April 4, 2024

**Re: XM at Petroglyphs (Tierra Buena Apartments)
Erosion and Sediment Control Plan
Engineer's Stamp Date 3/26/24 (C11E002)**

Based on the information in your submittal received on 3/26/24, the ESC plan cannot be approved until the following comments are addressed.

C1

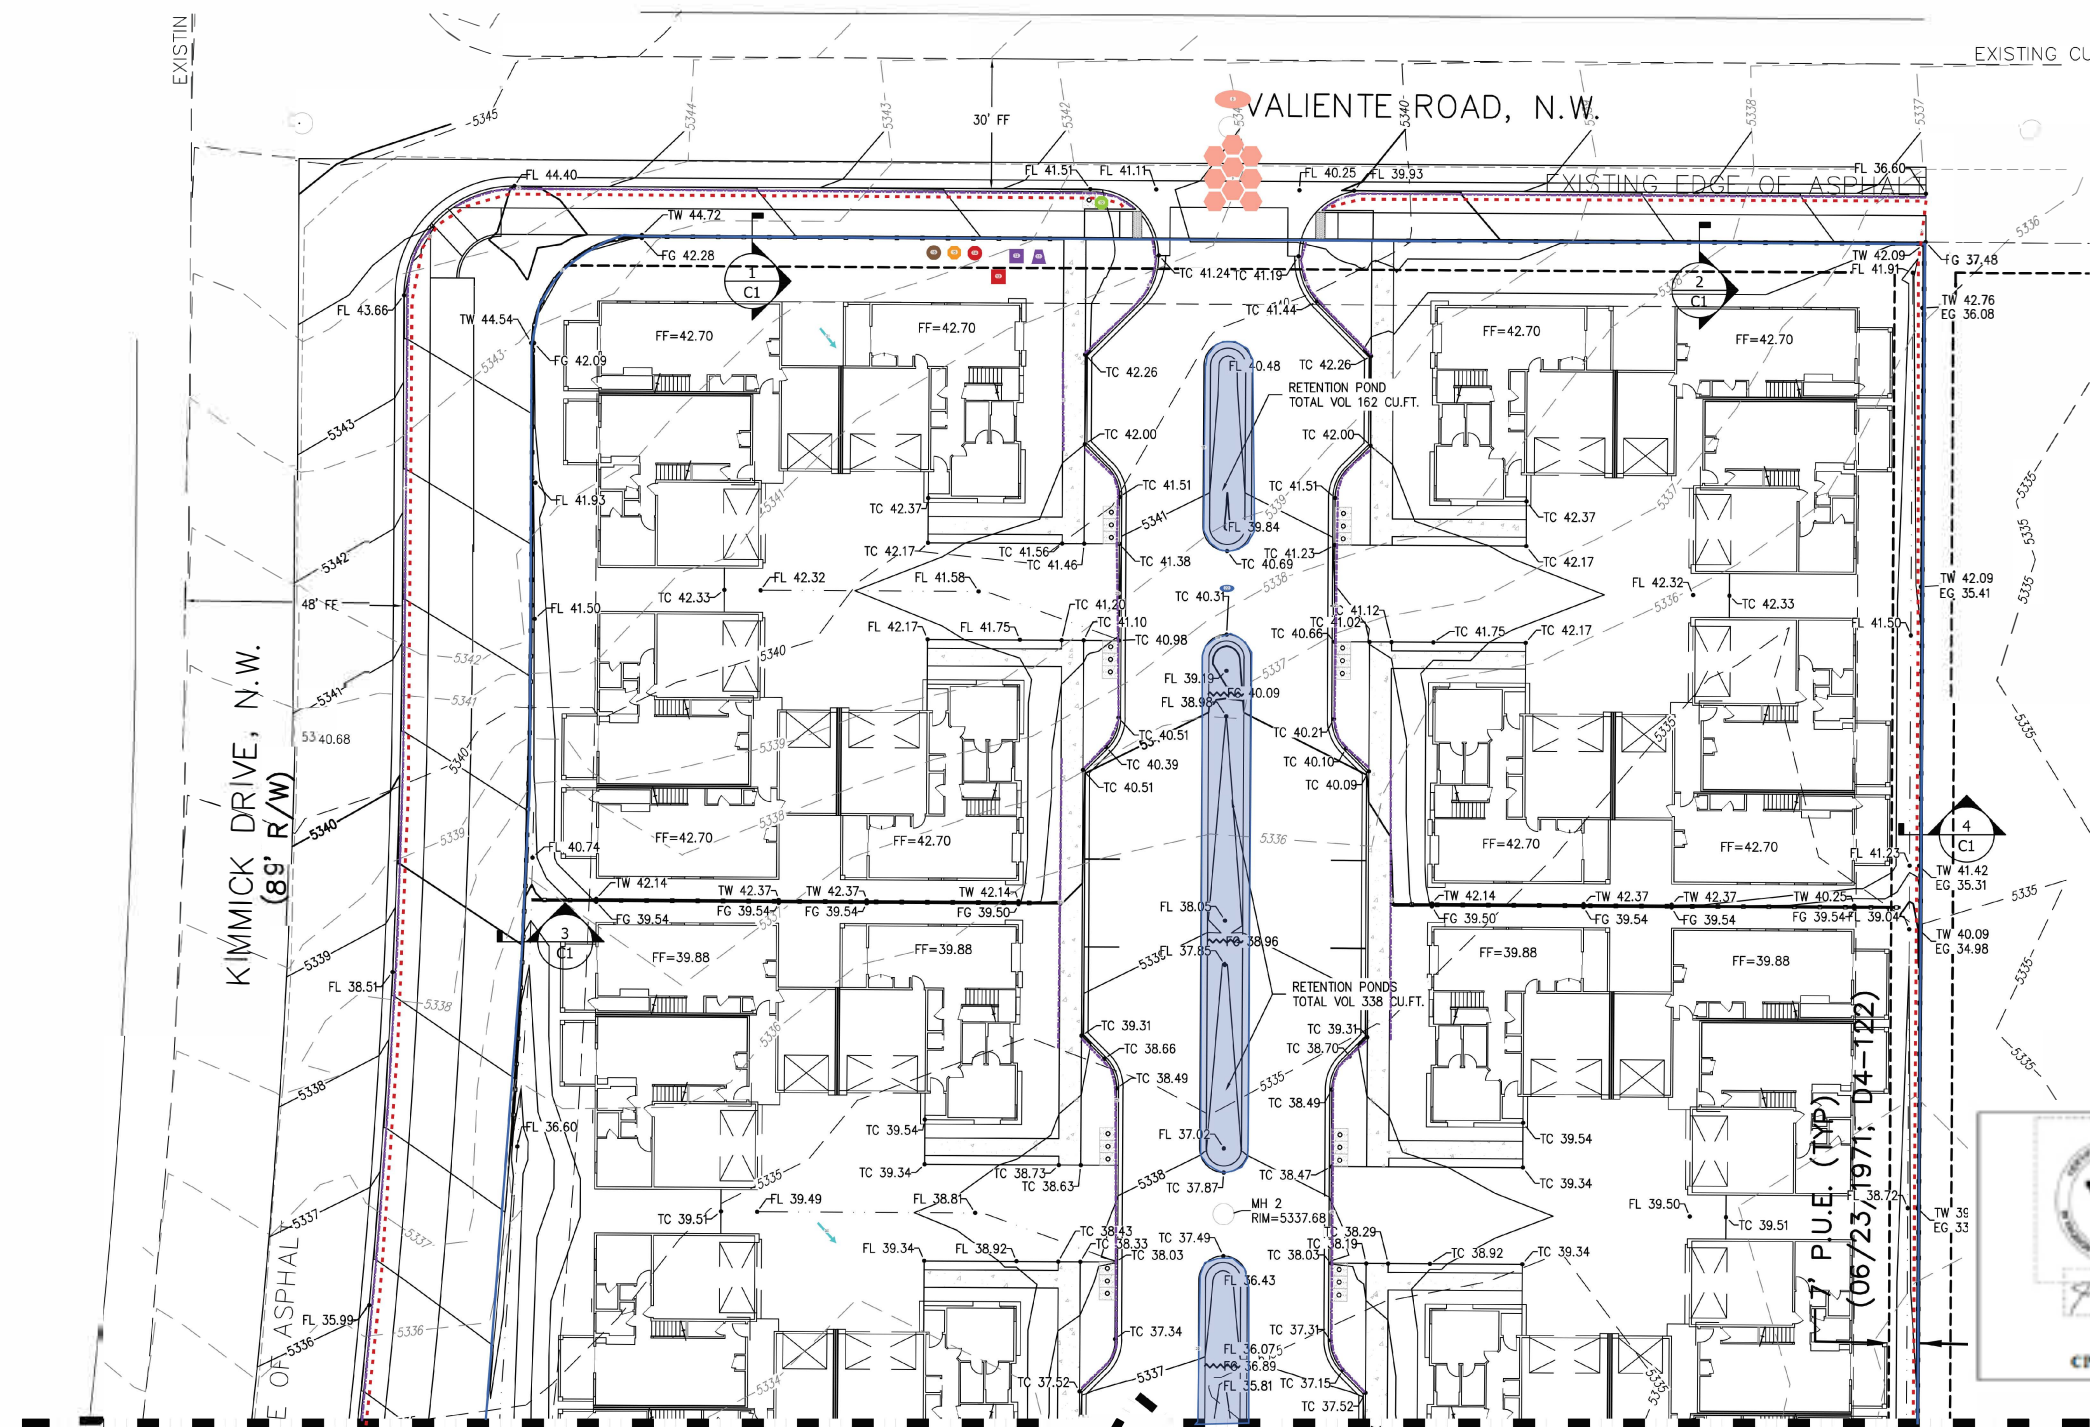
3. The Limit of Disturbance & Property Boundary are shown as a single line type in the legend, but they are not located at the same place, so a separate line type for each will have to be shown in the legend and on the ESC Plans. The adjacent street improvements will be constructed under a City Work Order and are part of the land-disturbing activities of this project. The southerly Limit of Disturbance is unclear, but the plan seems to show a new sidewalk on the south side of the street. Is that the south limit?

4. Cutback curbs are only feasible where the street is constructed before the buildings, which isn't likely in this multifamily development. Provide a construction sequence per CGP 7.2.3.f beginning with the initial establishment of the BMPs, posting of permit coverage, grading, utility construction, building construction, onsite and offsite C&G, paving, and sidewalks, and ending with stabilization, removal of BMPs, and filing NOT.

5. Label street slopes steeper than 2.5% and add check dams or wattles every 50 across the concentrated flow paths.

6. Replace the old City Standard Notes with the current (6/16/23) version.
7. I can't tell the difference between building, sidewalk, asphalt, and dirt on the ESC Plan. These structures must be clearly identified in the SWPPP per CGP 7.2.4.b.vi. The same information is required in the ESC Application. You may attach a copy of the Site Plan to the SWPPP and the ESC Application to address this requirement.
